Your ref:  
Our ref: 23/02102/F  
Please ask for: Lynn-Marie Elliott  
Direct dial:  
E-mail: borough.planning@west-norfolk.gov.uk

Details: **PROPOSED SIDE EXTENSION FOLLOWING DEMOLITION OF SIDE PORCH (CURRENTLY USED AS UTILITY) AT 15 RAILWAY ROAD, DOWNHAM MARKET, PE38 9DX at 15 Railway Road Downham Market Norfolk PE38 9DX**

REAR ELEVATION - 1:100
SOUTH

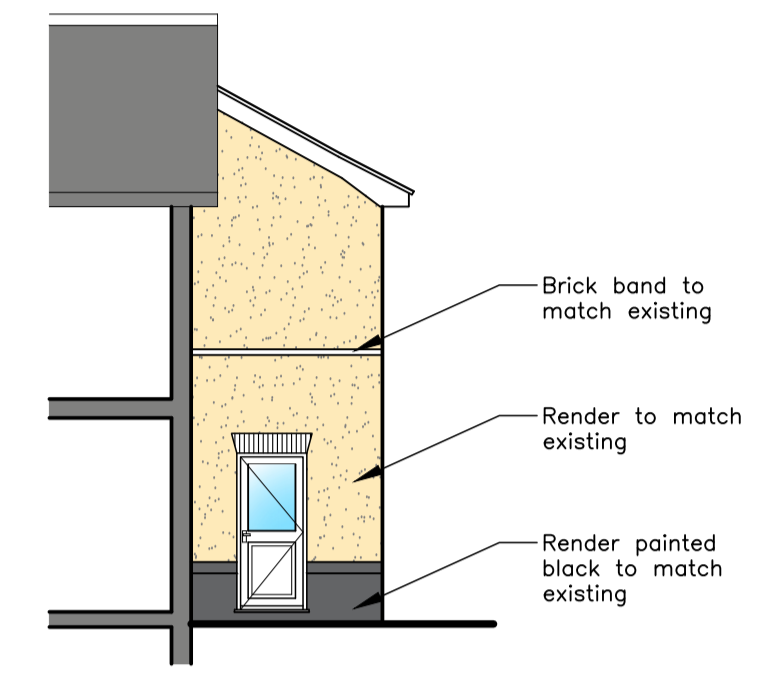
1. The annotation on the drawing(s) submitted with your application refers to the drawing being not to scale. Please remove any such reference for the purposes of the planning application.
2. Please can you check the scale as part of the site isn't measuring accurate.
